February 14, 2017

**RE: Bosque Plaza – Amended Site Development Plan for Subdivision
Project #1004167**

The purpose of this letter is to explain the modifications that have been made to the Site Development Plan for Subdivision Amendment for our project at the corner of Coors and La Orilla Road. The project was approved by the Environmental Planning Commission (EPC) on January 12th, 2017.

Conditions of Approval – 16EPC-40071 – January 12, 2017 – Amended Site Development Plan for Subdivision

**SITE PLAN FOR SUBDIVISION
BOSQUE PLAZA**

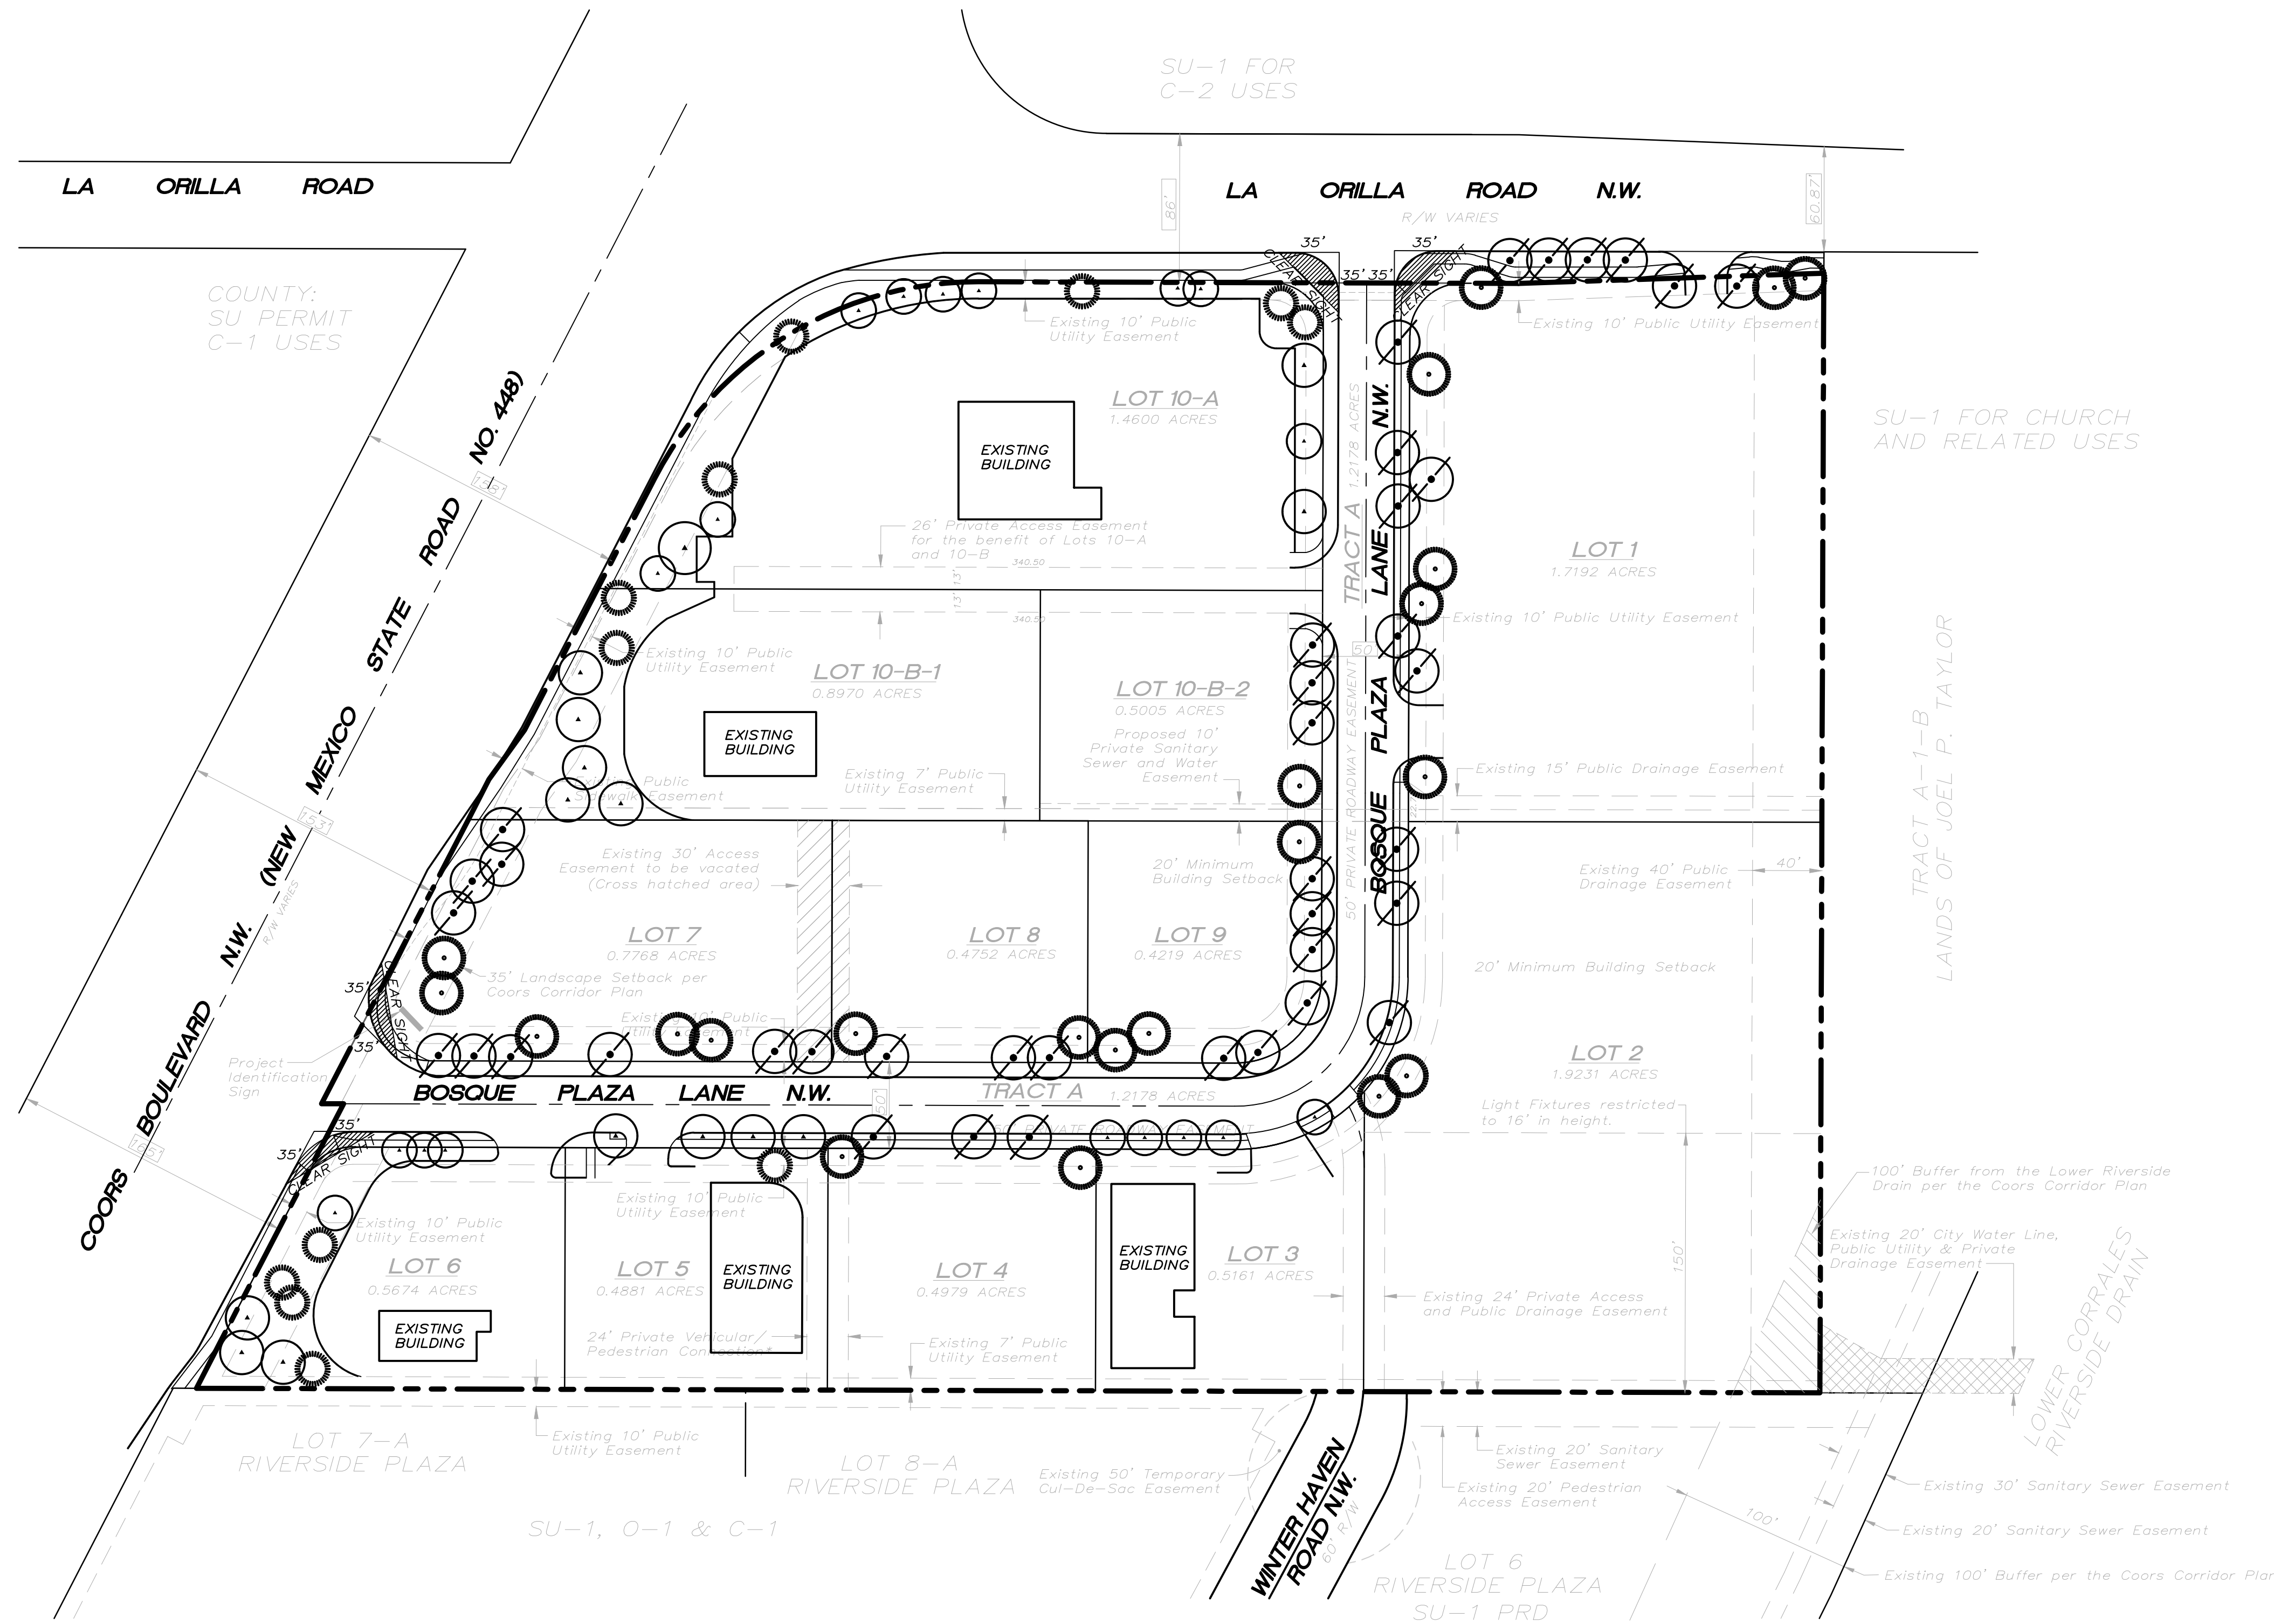
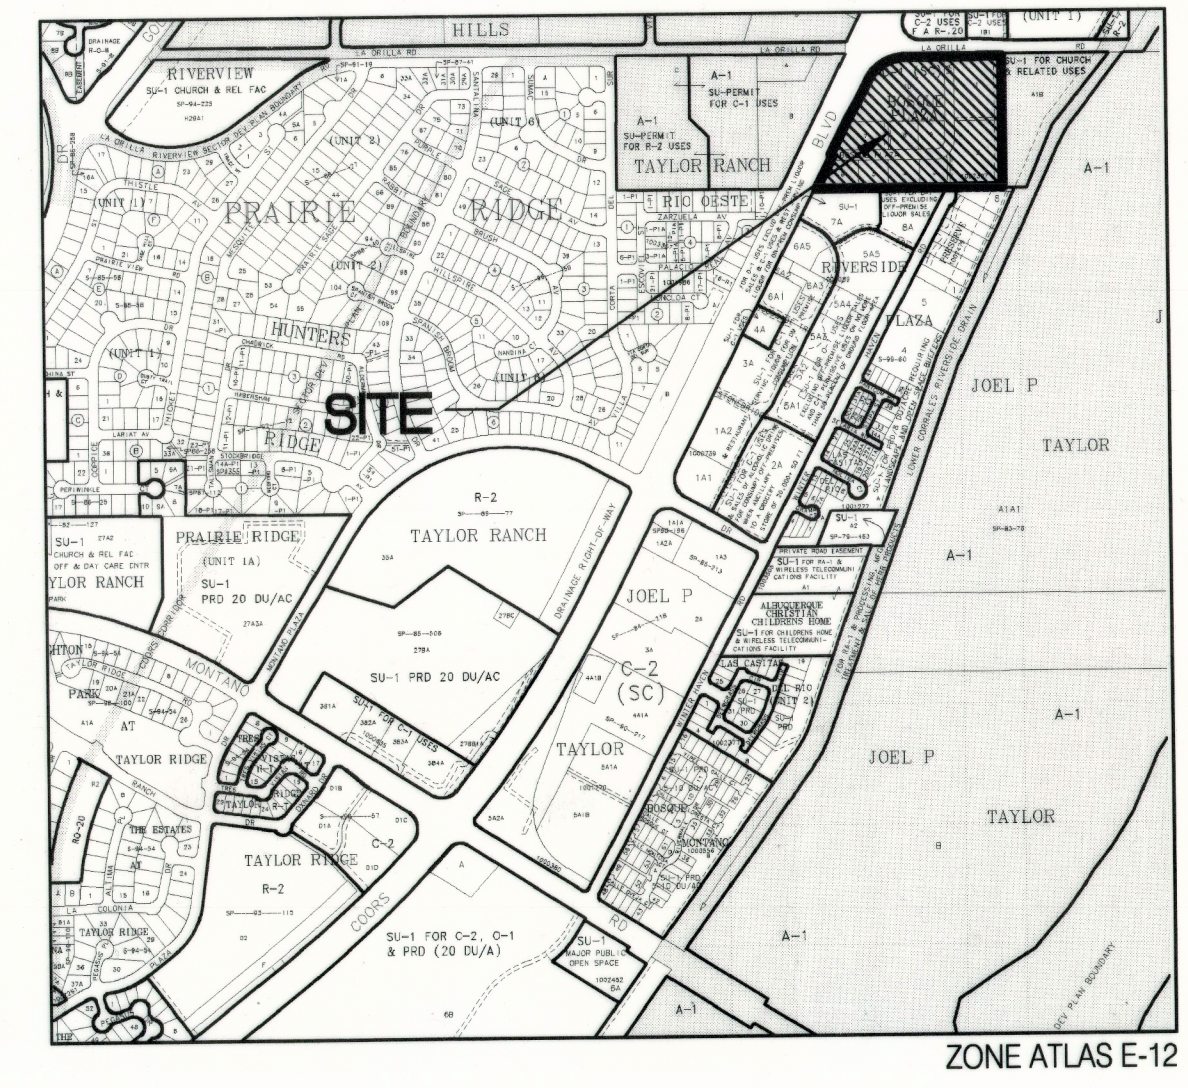
- Under the Access section on Sheet 1, the following sentence will be added: Access to Winterhaven Road shall remain restricted to pedestrian access.

5. A note shall be added to the Site Plan that states "Indoor Storage, Lot 1 only: FAR Maximum up to 1.0 only if the Coors Corridor Plan View Regulations for massing and height are in compliance, large truck access/turning movements are incorporated, and in accordance with an approved grading and drainage plan to ensure that the drainage is fully functional and aesthetically pleasing."

This sentence has been added to Sheet 1 to address the vehicular access between Bosque Plaza Lane and Winterhaven Road.

This note has been added to Sheet 1. These items will be addressed at the Site Plan for Building Permit stage.

BOSQUE PLAZA DESIGN STANDARDS

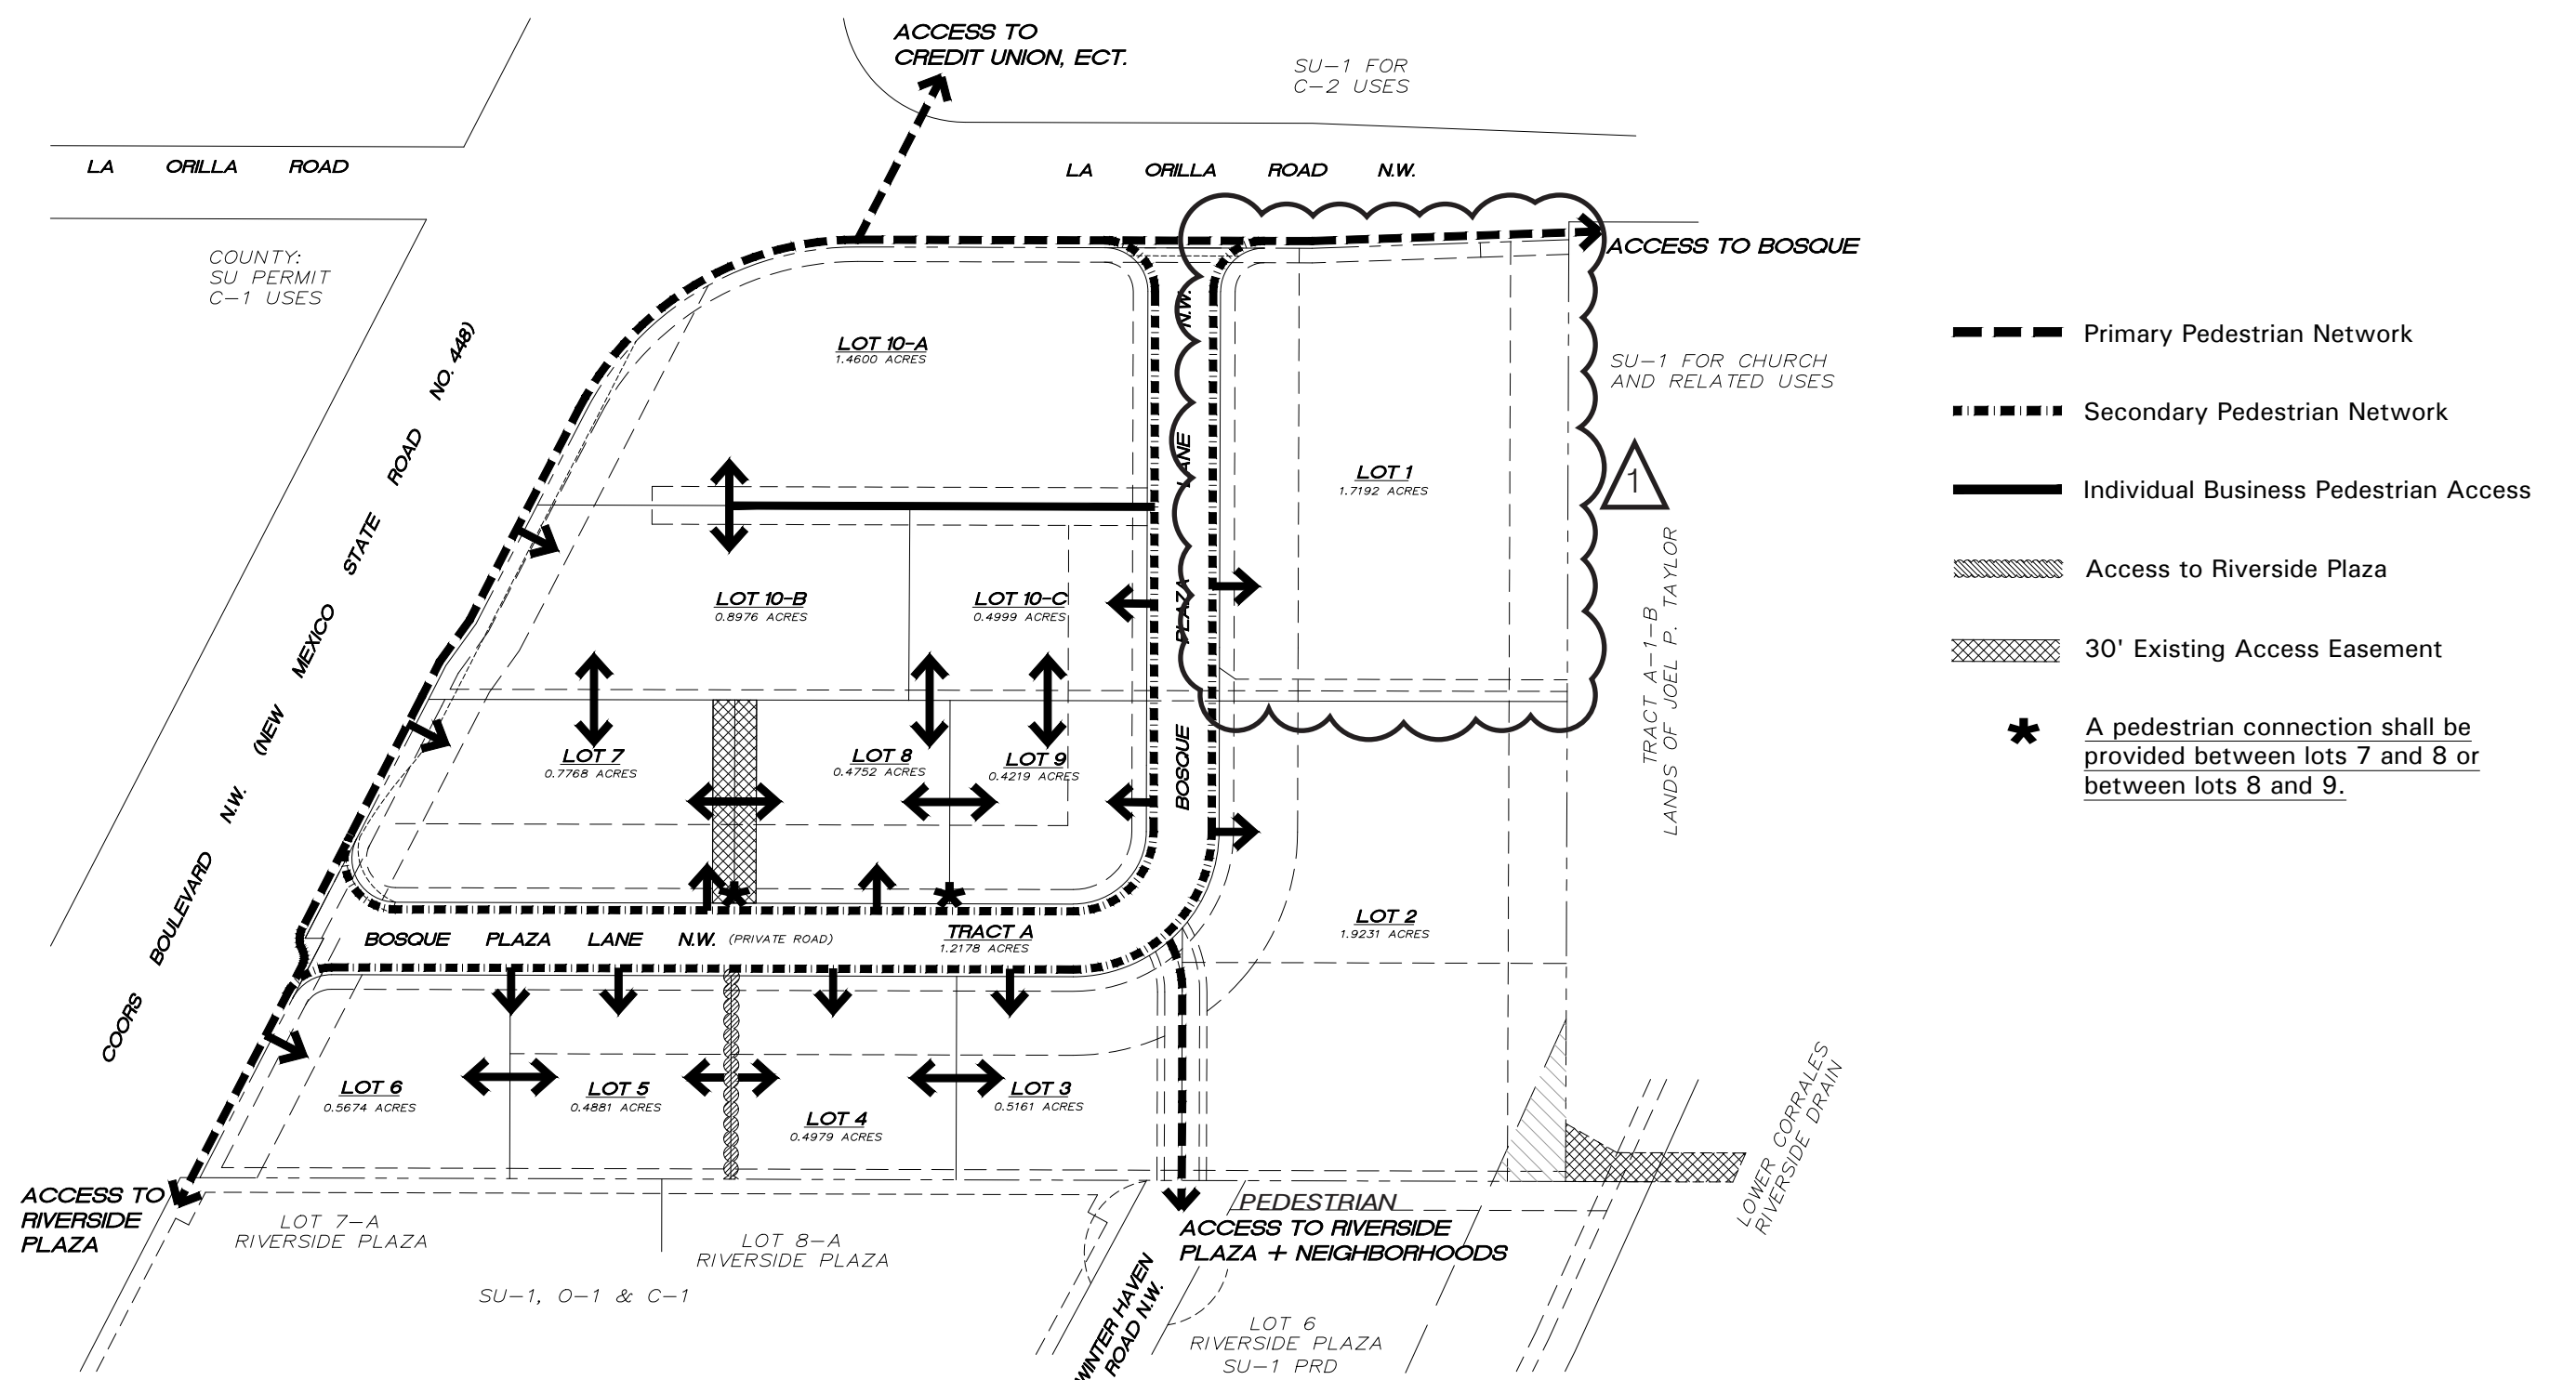
- Under section L. Pedestrian Plan on Sheet 3, the following bullet will be added:
Pedestrian only access is indicated on the Plan from Winterhaven Road to Bosque Plaza Lane (Per condition #4 original Notice of Decision). A note shall be added to the Pedestrian plan that restricts access to pedestrian only.

6. Section G.3.3 Territorial Style Elements for Larger Buildings (Sheet 3) should reflect the changes provided by the application (attachment 1) and read into the record.

These notes have been added to Sheet 3 to help clarify the vehicular access between Bosque Plaza Lane and Winterhaven Road.

The changes read into the record at the EPC hearing on January 12th, 2017 have been added to Sheet 3 of the Bosque Plaza Site Plan for Subdivision. These changes clarify the design of a "larger building" allowed on Lot 1.
